**Town & Country Planning Act 1990 (as amended) s211 Notice
Application for Prior Notification of Work to Tree(s) in a Conservation Area**

Development Fell 1 No. Field Maple Tree, raise lower crown of 1No Oak Tree and crown reduction to 1No. Oak tree within the Craigweil House, Aldwick Conservation area.

Location 36 Kingsway Craigweil Estate Bognor Regis

SITE PLAN

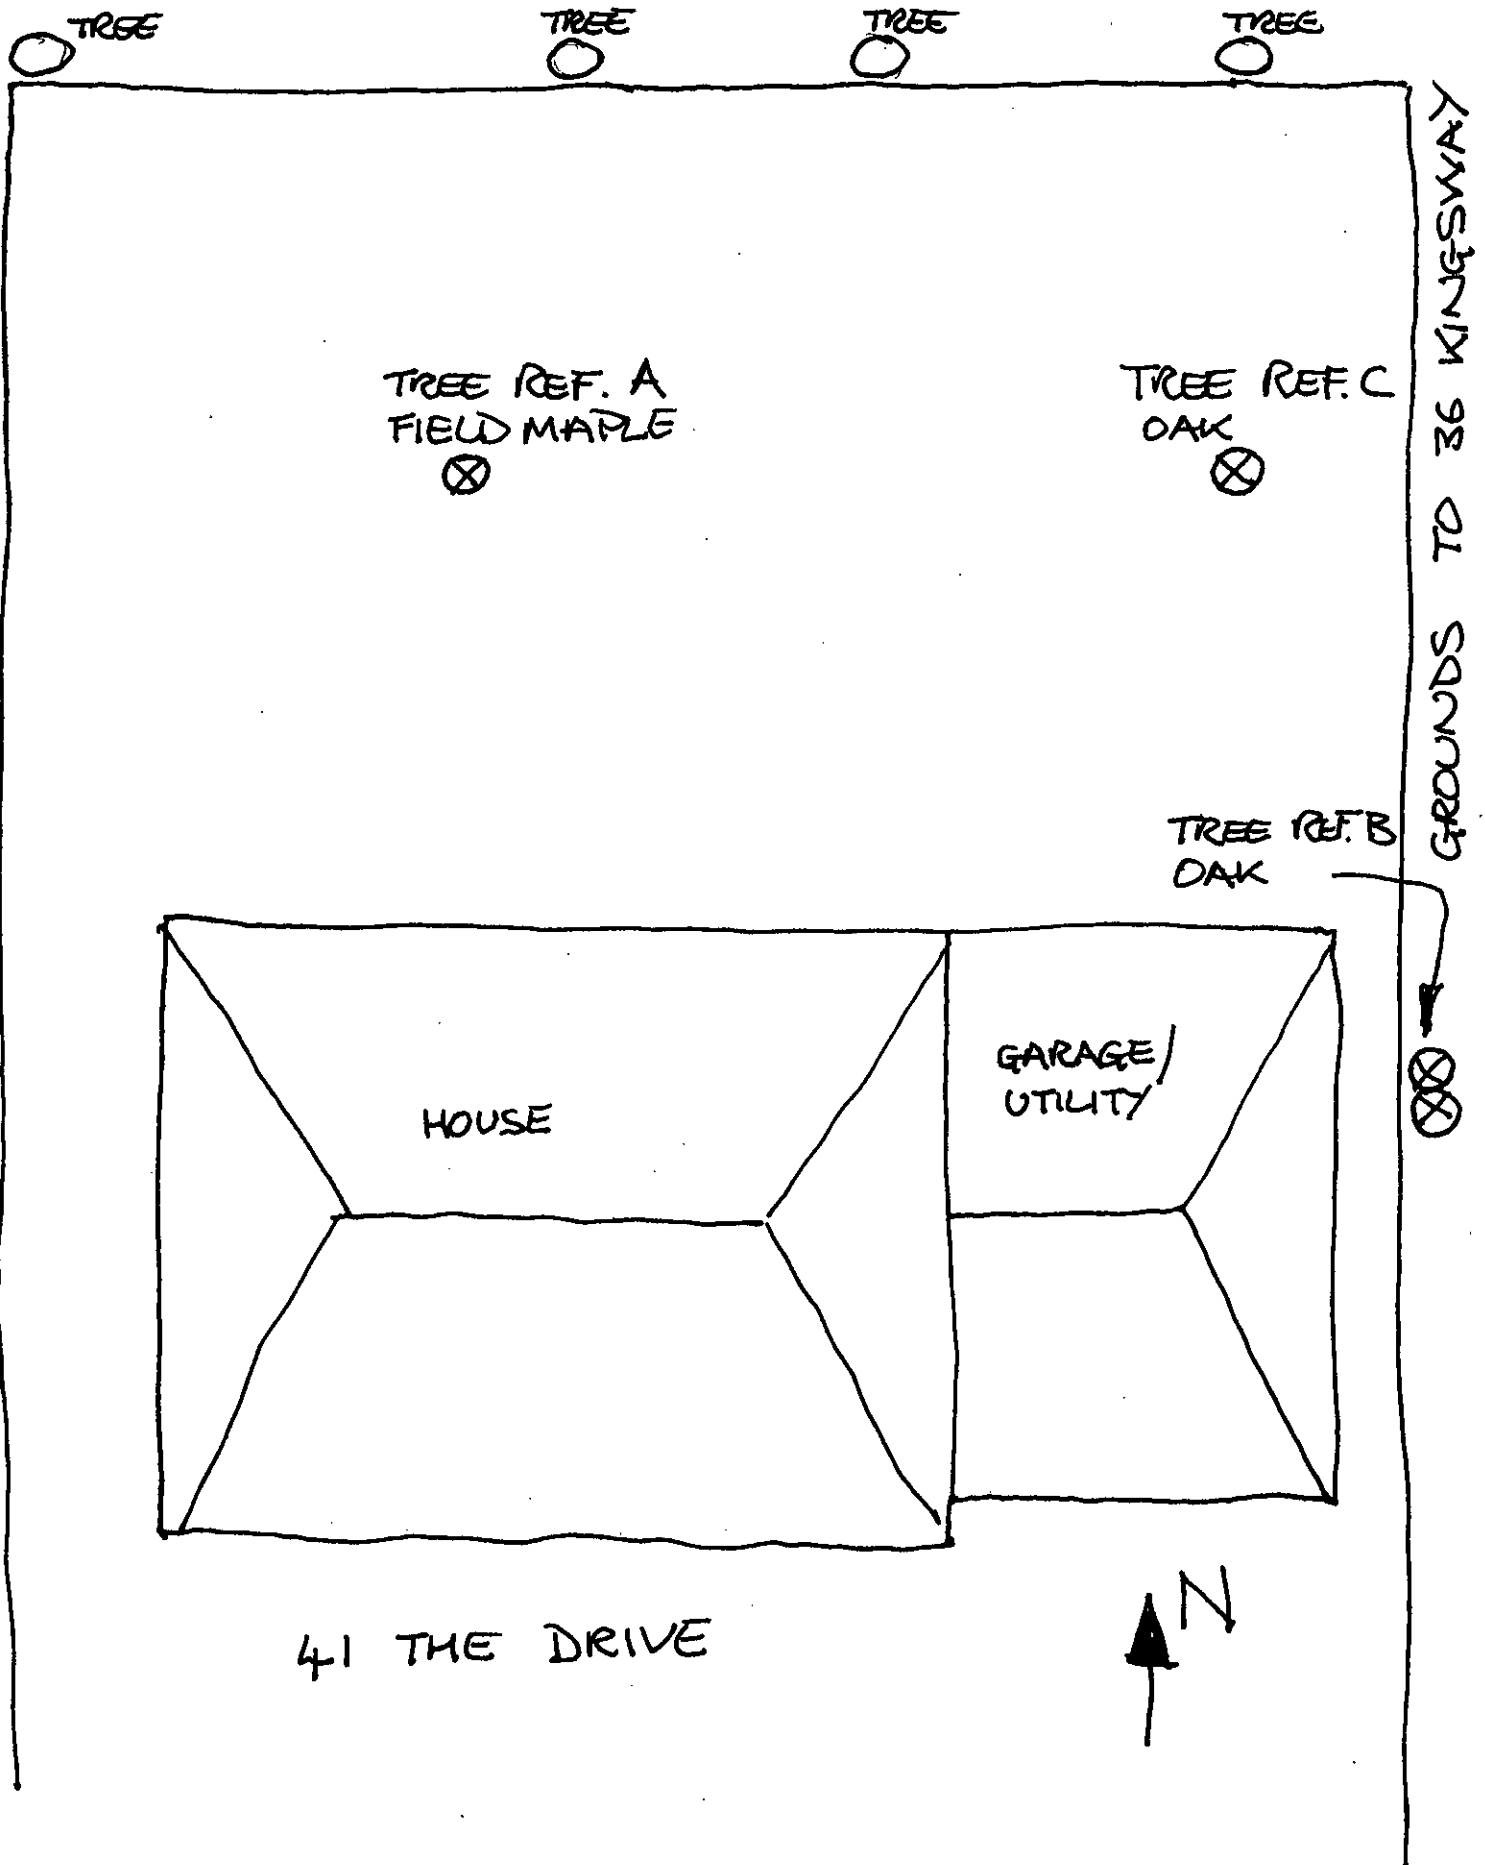
Please confirm if Crown Lift to 1No. Oak Tree (Ref B).

Please confirm in metres branch reduction to 1No. Oak tree (Ref B).
